Beths Grammar School
Hartford Road, Bexley, DA5 1NE

**PROPOSED SCHEME AMENDMENTS
APPLICATION DESIGN STATEMENT**

34955-BGL-AX-XX-RP-A-00020 P01

PROJ NO	AUTHOR	VOLUME	LEVEL	DOCTYP	ROLE	DRW NO	REV NO
34955	BGL	A1	ZZ	DR	A	14013	P03

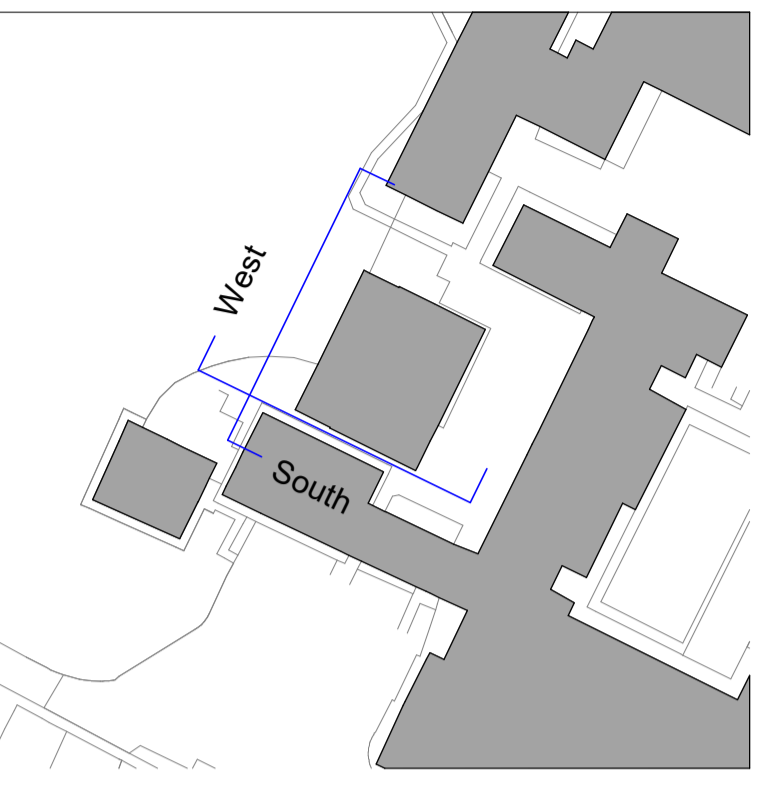
Ref.No	Subject / Consented design	Proposed Amendment	Justification	Consented Drawings Affected	Proposed Drawings	Proposed Drawings Changes Mark-up
E1	Building elevations	Previous windows/doors alignment as per application 20/02454/FULM	As a result of the design development and to ensure the building is constructed to brick dimensions, some windows and doors had to be repositioned or slightly amended to suit requirements.	32169-BGL-A1-XX-DR-A-1400-P 32169-BGL-A1-XX-DR-A-1401-P 32169-BGL-A1-XX-DR-A-1402-P 32169-BGL-A1-XX-DR-A-1403-P	34955-BGL-A1-ZZ-DR-A-14012-P03 34955-BGL-A1-ZZ-DR-A-14013-P03	34955-BGL-A1-ZZ-DR-A-14100-P03 34955-BGL-A1-ZZ-DR-A-14101-P03
E2	Building elevations	Brick colour changed from red to grey	Required by the client to minimize the look of the second floor	32169-BGL-A1-XX-DR-A-1400-P 32169-BGL-A1-XX-DR-A-1401-P 32169-BGL-A1-XX-DR-A-1402-P 32169-BGL-A1-XX-DR-A-1403-P	34955-BGL-A1-ZZ-DR-A-14012-P03 34955-BGL-A1-ZZ-DR-A-14013-P03	34955-BGL-A1-ZZ-DR-A-14100-P03 34955-BGL-A1-ZZ-DR-A-14101-P03

E3	Building elevations	Brick colour changed from grey to red	Required by the client to create a cohesive design with item E2	32169-BGL-A1-XX-DR-A-1400-P 32169-BGL-A1-XX-DR-A-1401-P 32169-BGL-A1-XX-DR-A-1402-P 32169-BGL-A1-XX-DR-A-1403-P	34955-BGL-A1-ZZ-DR-A-14012-P03 34955-BGL-A1-ZZ-DR-A-14013-P03	34955-BGL-A1-ZZ-DR-A-14100-P03 34955-BGL-A1-ZZ-DR-A-14101-P03
E4	Building elevations	New plant room doors added as per MEP requirements	New electrical plant room required internally together with external access required for the plant room	32169-BGL-A1-XX-DR-A-1400-P 32169-BGL-A1-XX-DR-A-1401-P 32169-BGL-A1-XX-DR-A-1402-P 32169-BGL-A1-XX-DR-A-1403-P	34955-BGL-A1-ZZ-DR-A-14012-P03 34955-BGL-A1-ZZ-DR-A-14013-P03	34955-BGL-A1-ZZ-DR-A-14100-P03 34955-BGL-A1-ZZ-DR-A-14101-P03
E5	Building elevations	Toilet high-level windows removed	To avoid clashing issues with internal cubicles	32169-BGL-A1-XX-DR-A-1400-P 32169-BGL-A1-XX-DR-A-1401-P 32169-BGL-A1-XX-DR-A-1402-P 32169-BGL-A1-XX-DR-A-1403-P	34955-BGL-A1-ZZ-DR-A-14012-P03 34955-BGL-A1-ZZ-DR-A-14013-P03	34955-BGL-A1-ZZ-DR-A-14100-P03 34955-BGL-A1-ZZ-DR-A-14101-P03

DRAWING TITLE
Level 03 - Proposed Roof GA Plan

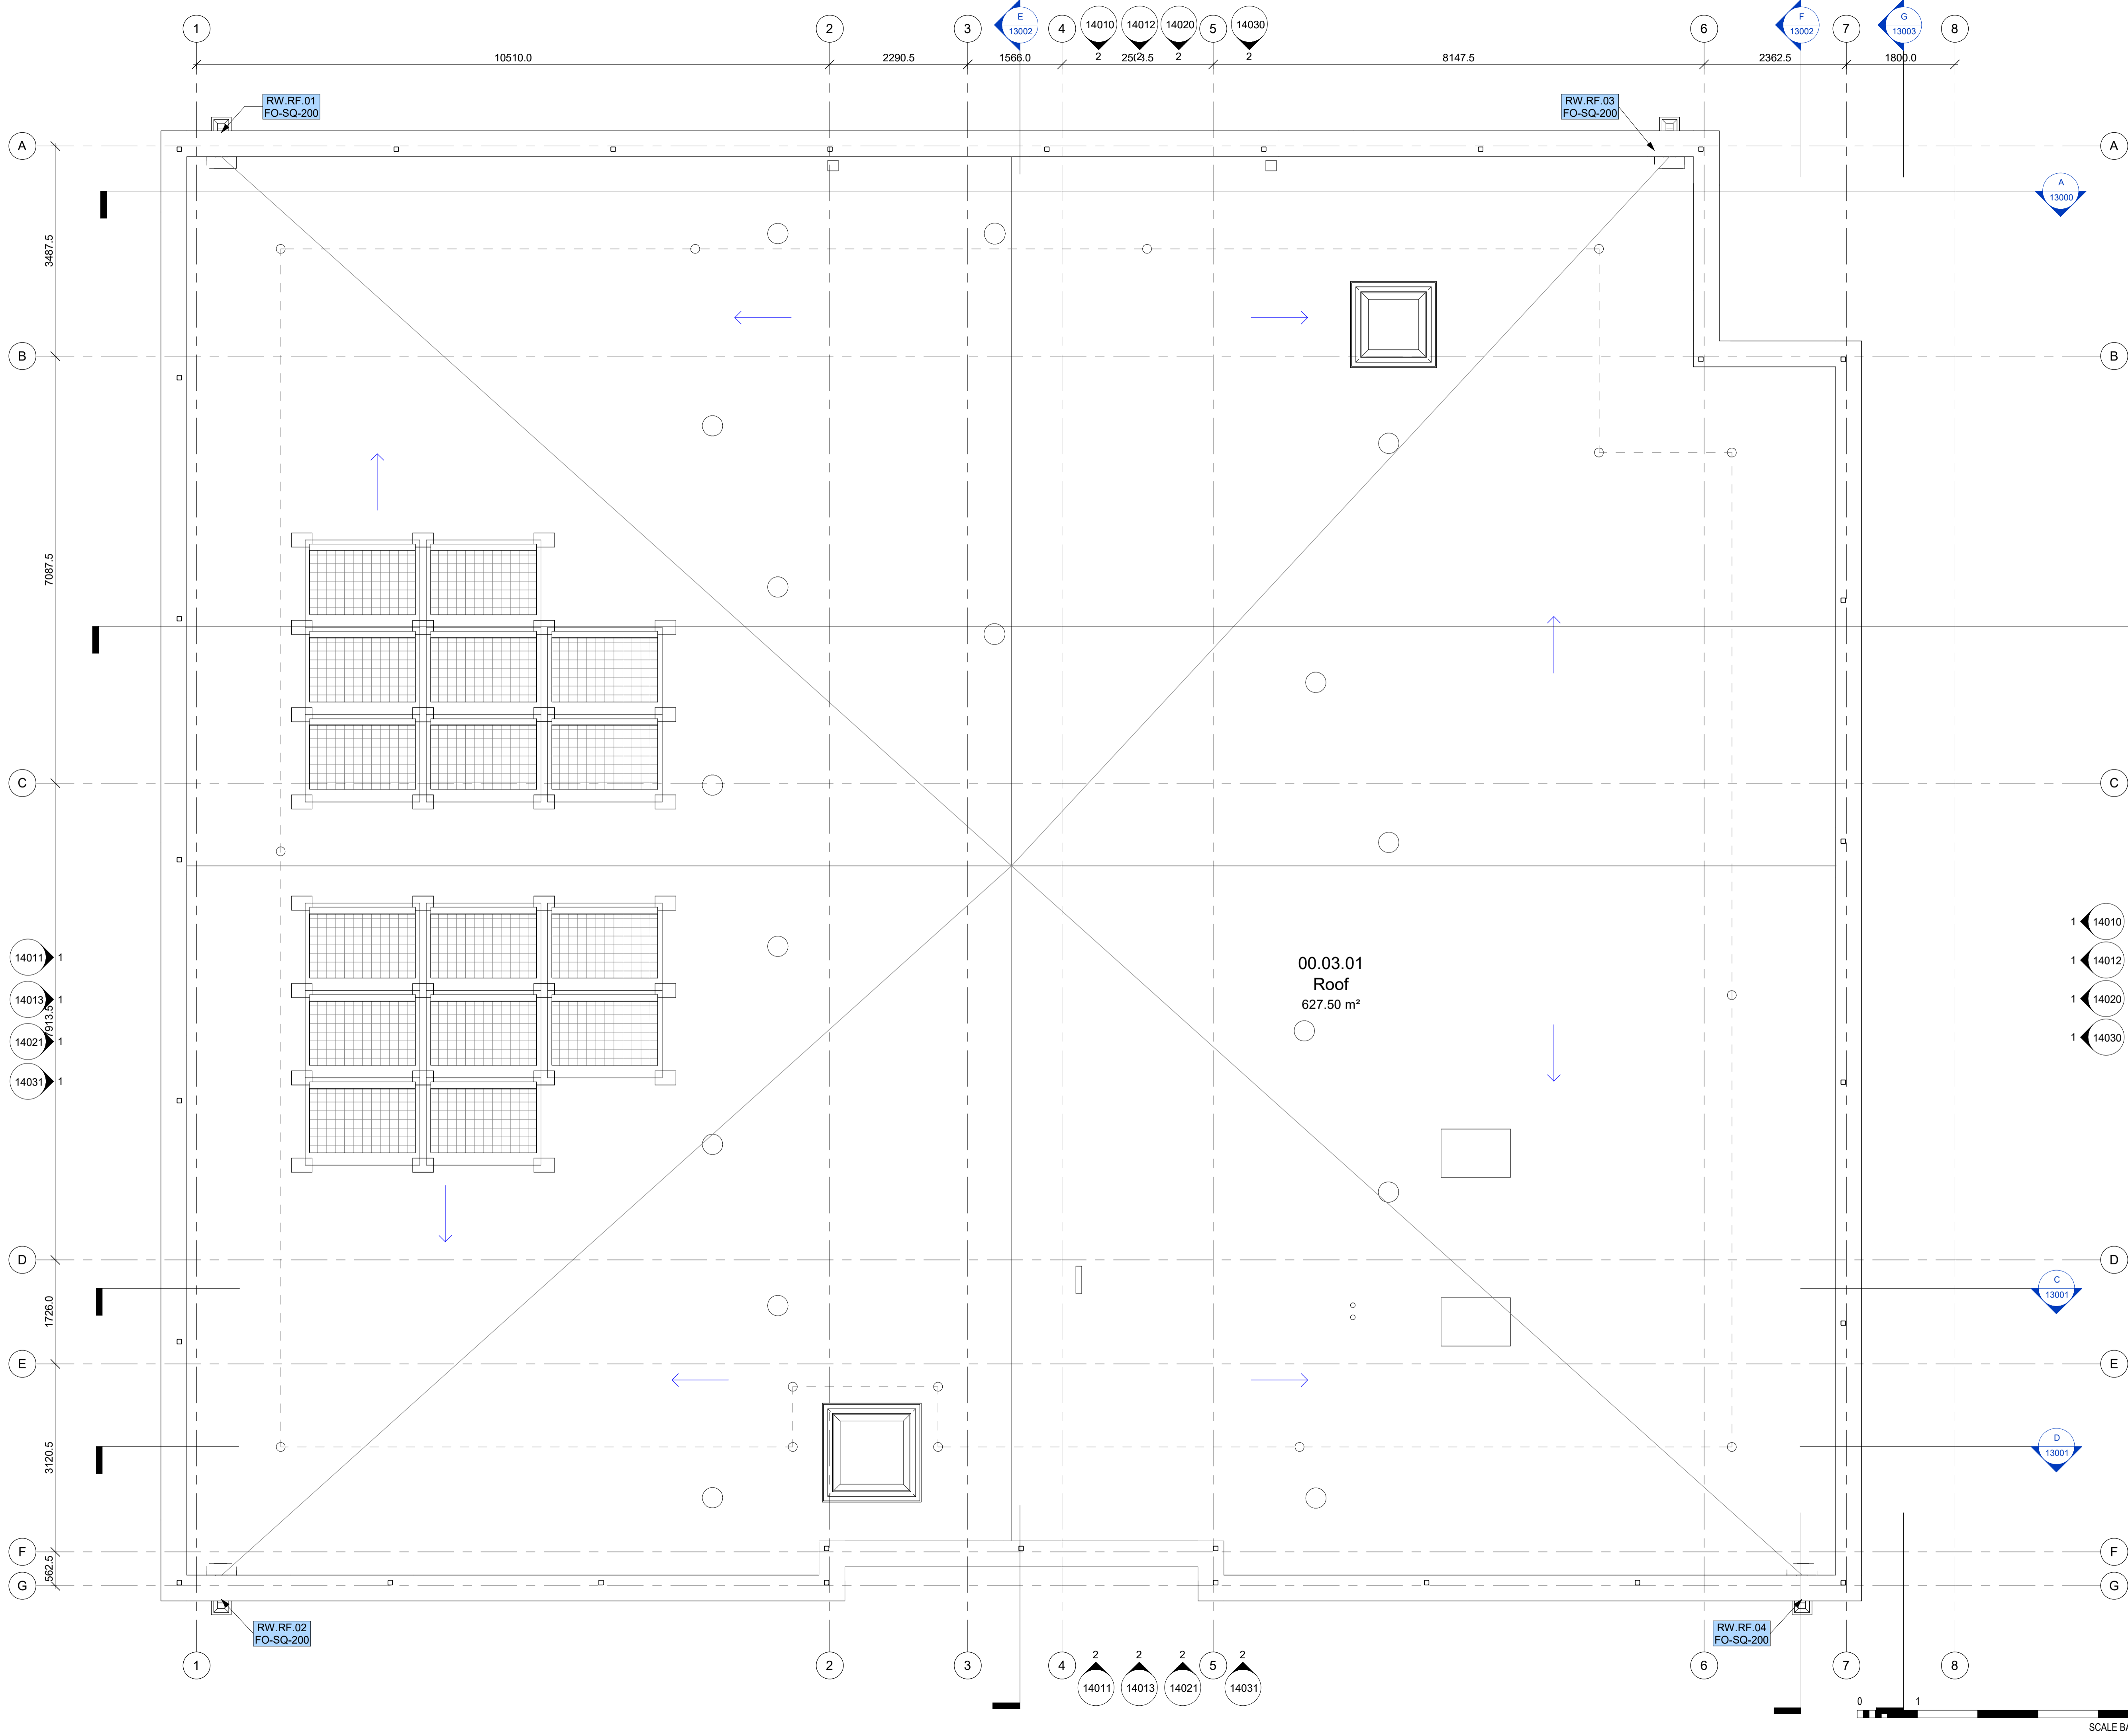
L5	Building layouts	PV panels added as per MEP requirements	Introduction of photovoltaic panels (PV) on the roof following advice to achieve required energy strategy values as per planning approval	32169-BGL-A1-R1-DR-A-1203-P	34955-BGL-A1-03-DR-A-12003-C03	34955-BGL-A1-03-DR-A-12053-P02
